OFFICIAL NOTICE OF DECISION

CITY OF ALBUQUERQUE  
PLANNING DEPARTMENT  
DEVELOPMENT REVIEW BOARD

**Project# 1005278**

- 15DRB-70170 VACATION OF EASEMENTS
- 15DRB-70171 SIDEWALK WAIVER
- 15DRB-70172 TEMP DEF SIDEWALK CONST
- 15DRB-70173 PRELIMINARY PLAT
- 15DRB-70174 SITE DEVELOPMENT PLAN FOR SUBDIVISION

**JUAN TABO HILLS - ESTATES
CONCEPTUAL UTILITY PLAN**

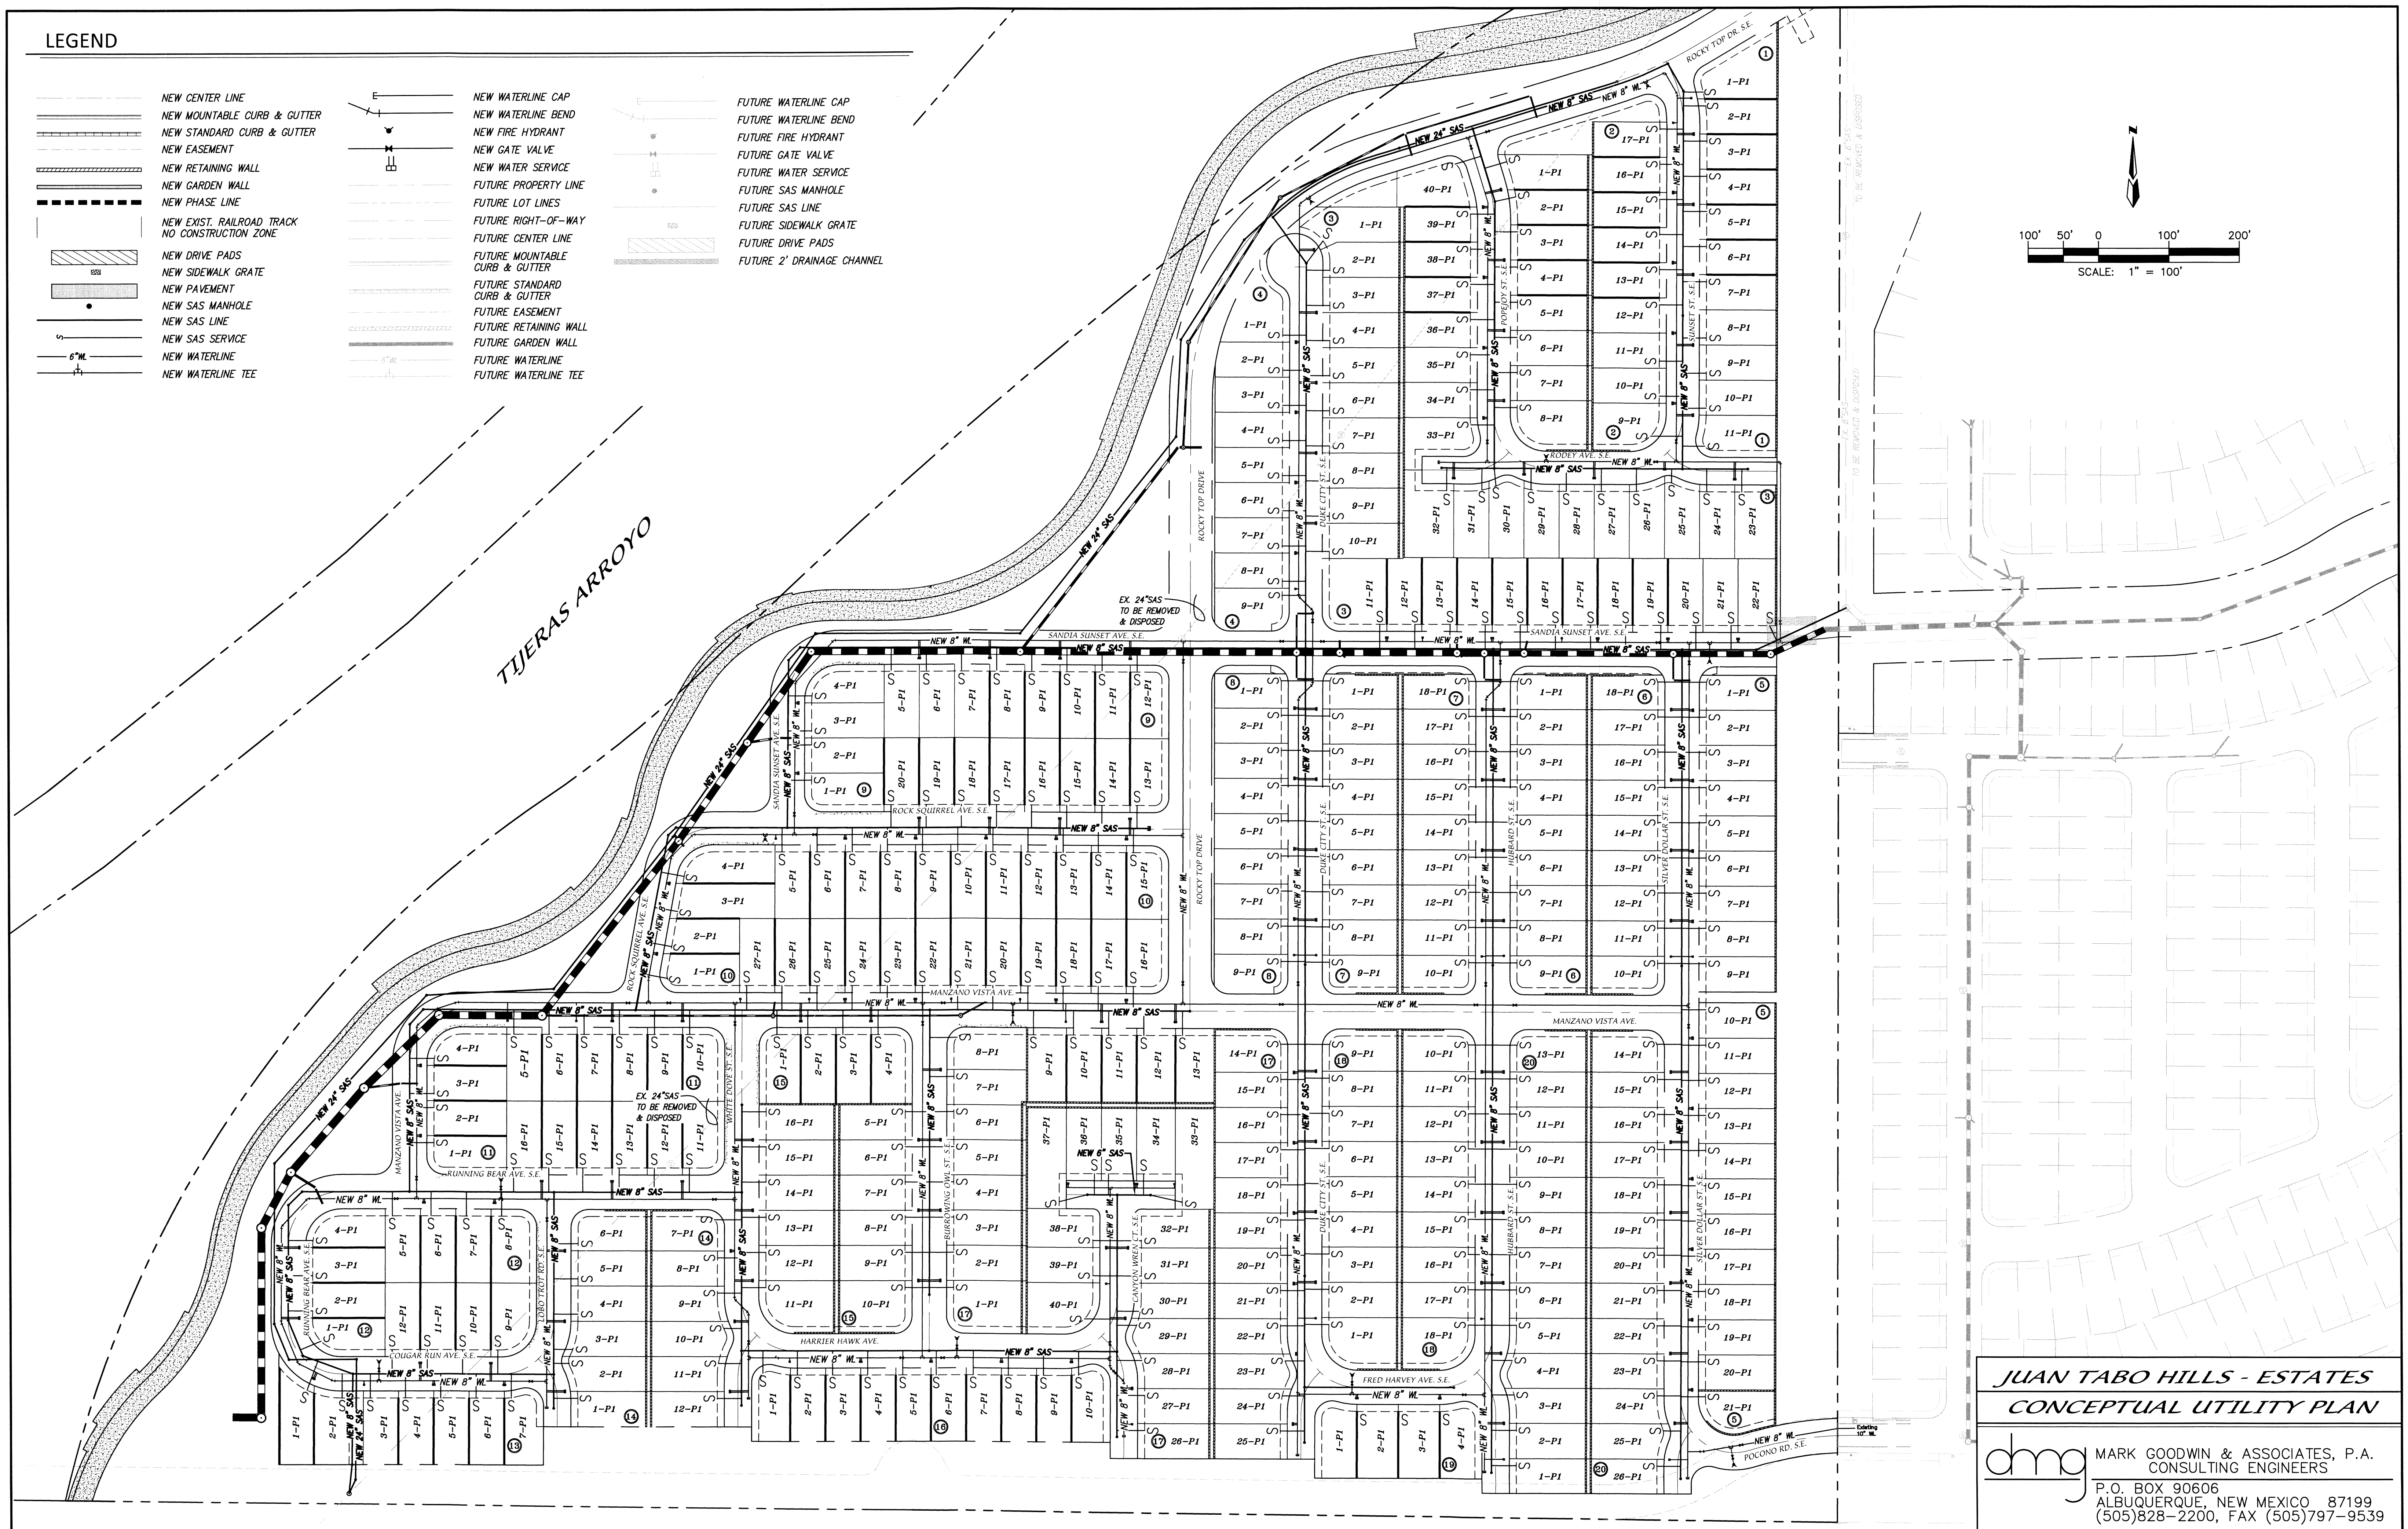
<p>ff. 8" waterline along Blue Ribbon Rd. and 8" waterline between Gallant Fox Rd. and Blue Ribbon Rd.</p> <p>iii. Infrastructure List states 6" waterline along Hubbard St. from Fred Harvey Ave to Lot 1 Block 20 and Utility Plan shows 8".</p> <p>iv. 6" waterline along Canyon Wren Ct. from North End of Cul-de-sac to Lot 26 Block 17 is shown as 8" waterline on Utility Plan. Plan shows 6" waterline along the hammerhead only.</p> <p>v. General comment: Areas where a proposed 6" waterline serves less than 8 lots can be served with a 4" waterline instead if fire hydrants are not being served from said line.</p> <p>vi. 6" waterline along White Dove St. from Harrier Hawk Ave. to Manzano Vista Ave. is shown as an 8" on the Utility Plan.</p> <p>vii. Include removal of existing 21" sanitary sewer interceptor.</p> <p>viii. Include removal of 8" collector located east of the project location that runs north/south.</p> <p>5. Preliminary Plat</p> <p>a. Easement D (existing 20' sanitary sewer easement) along east property line needs to be vacated as this line will be removed.</p>

LANDSCAPE PLAN

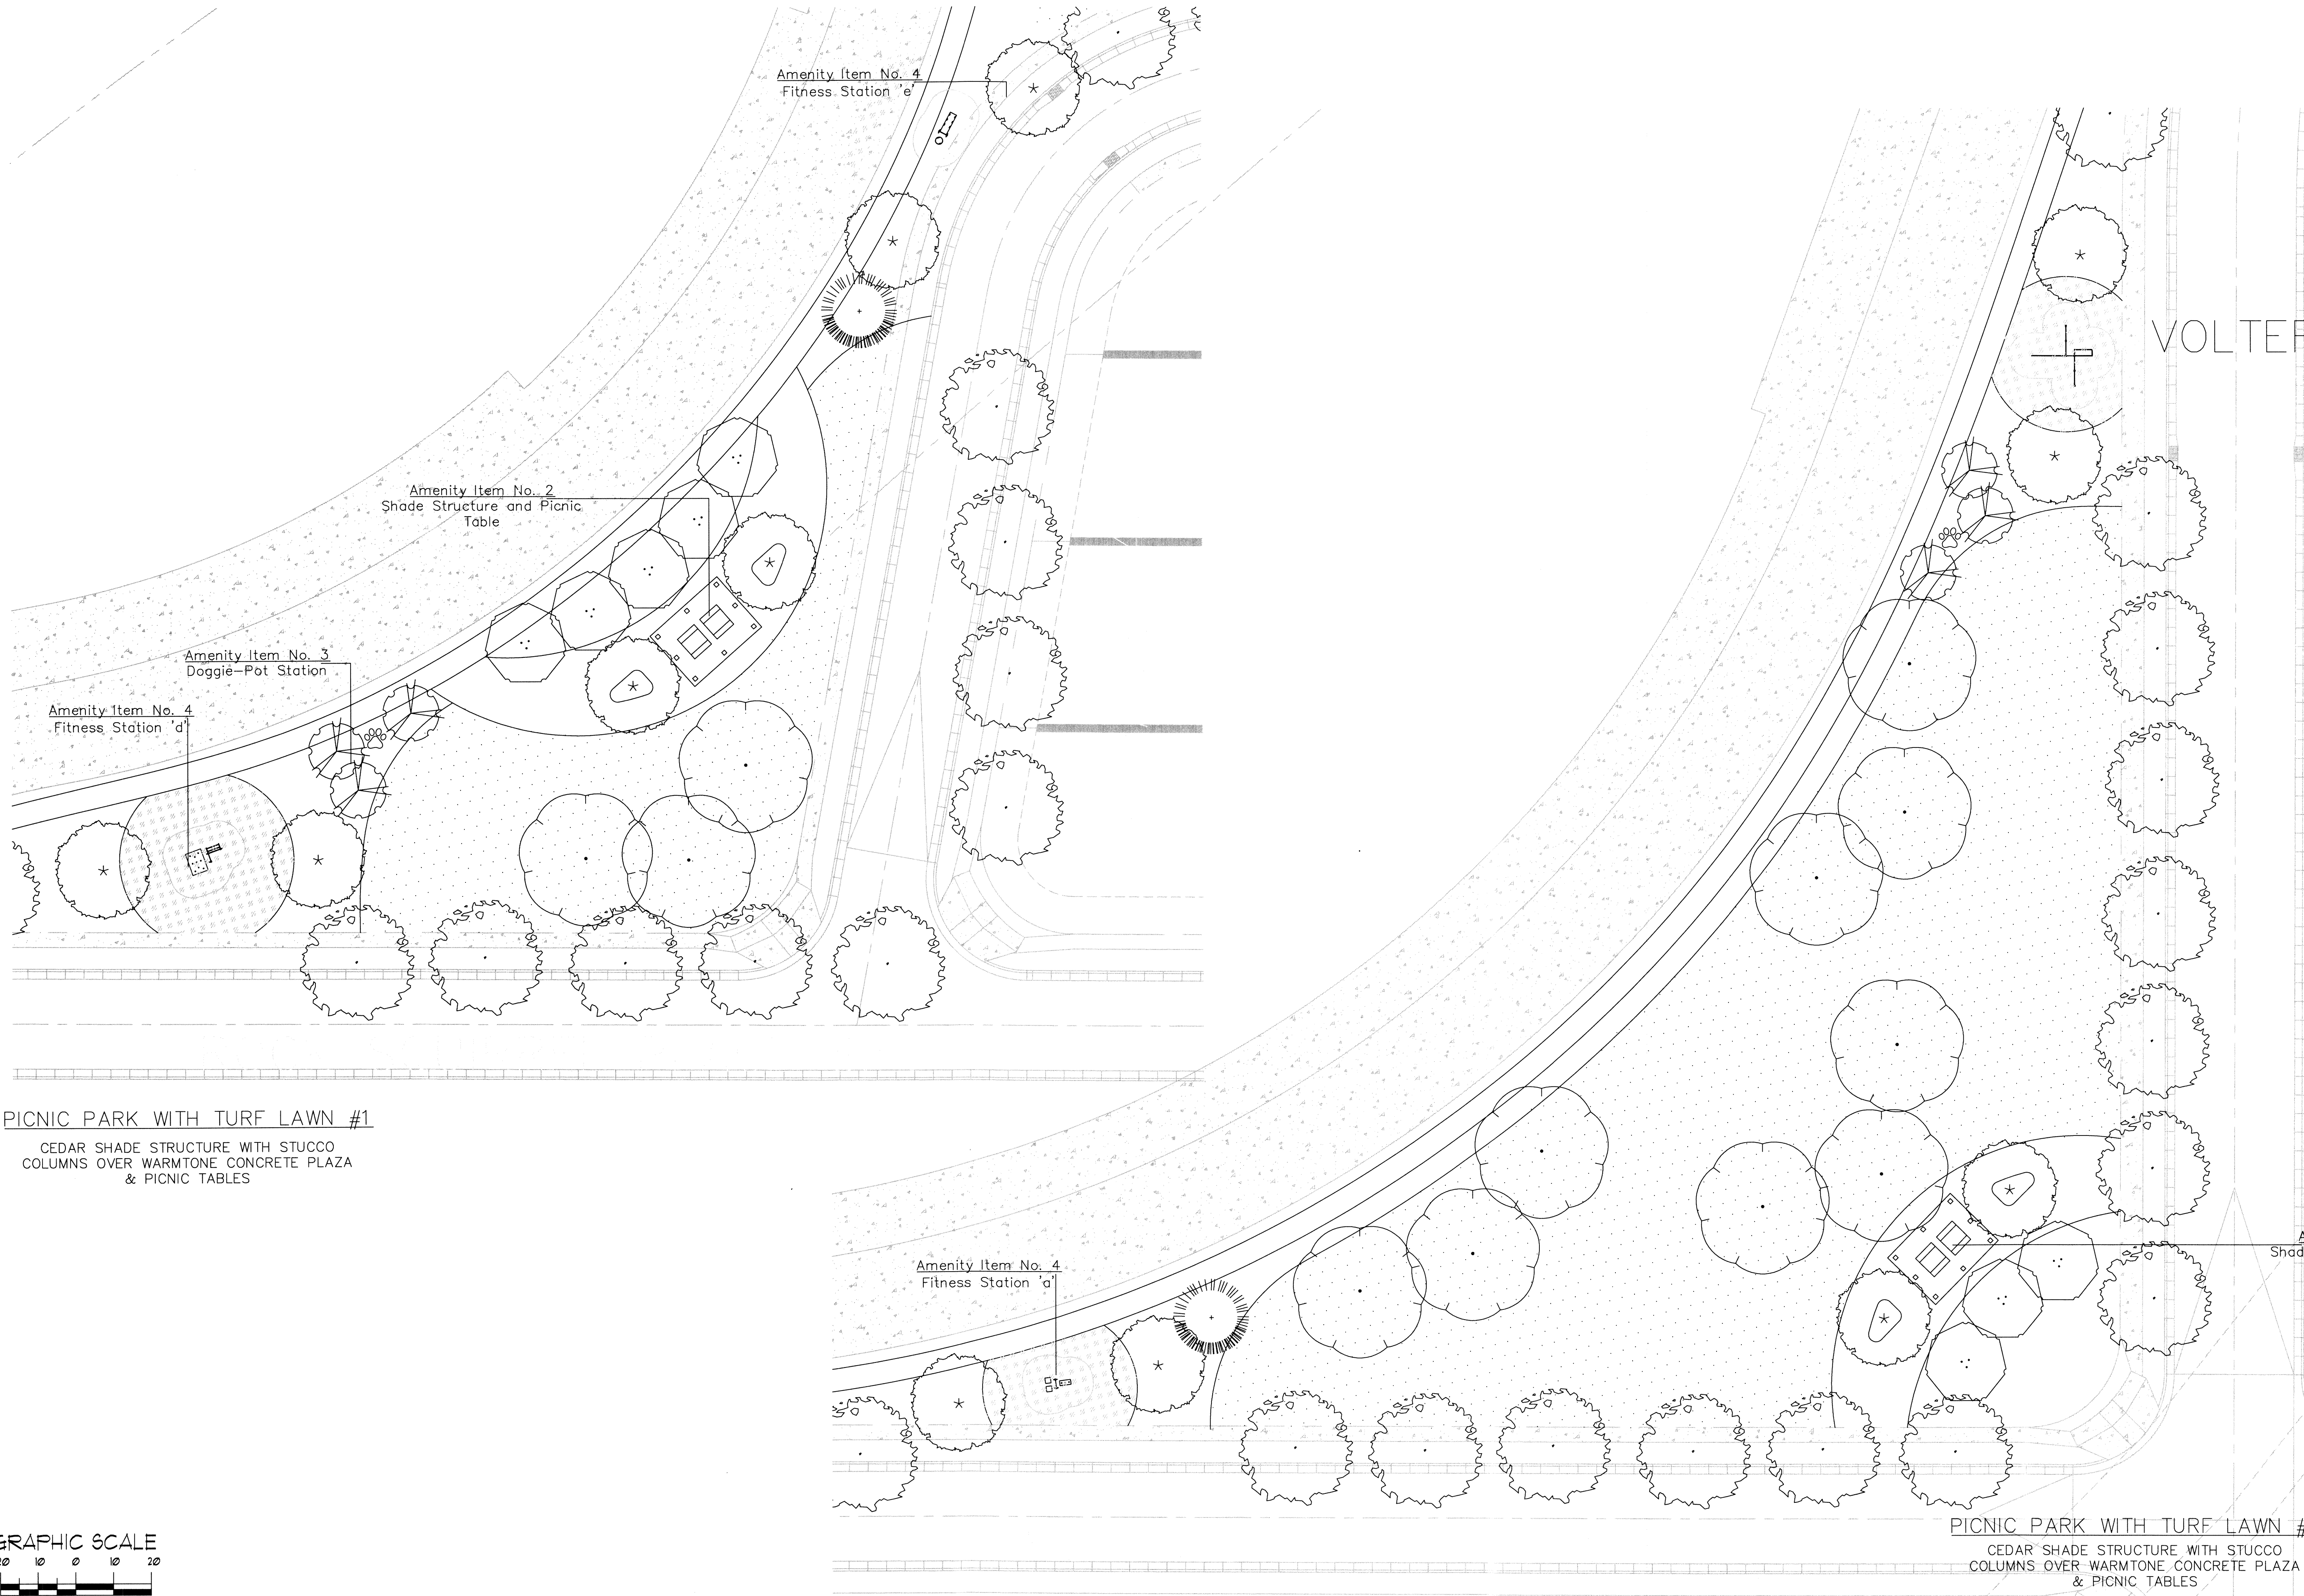
1. Amendment to the Pre-Annexation Agreement dated April 16, 2015 includes requirement for the Developer to construct a neighborhood park ....and "shall be designed, landscaped and have playground and recreational equipment for adults and children installed in accordance with City Standards..." There does not appear to be a playground or recreational equipment on the Landscape Plan showing the proposed development of the Park but other amenities are clearly indicated.

5. The Neighborhood Park will be owned and maintained by the HOA but will be available to the general public and will be built to City Standards. The site has some constraints that may affect its development, most significantly, the scour wall along the western edge. No trees may be planted within an appropriate distance of the scour wall due to risk of roots penetrating the Shotcrete which could cause the scour wall to fail. Specific information about the location and size of the underground utility easements and what infrastructure runs under the Park site is required. Information about grades are necessary to assess the slope on the Park site. We have not been provided spot elevations on the Park site and is necessary for us to assure that compliance with the Americans with Disabilities Act can be achieved. Coordination with the Corps of Engineers may be required regarding what type of protective railing or high tensile fencing may be used at the edge of the park so as not to affect the scour wall integrity and drainage capacity.
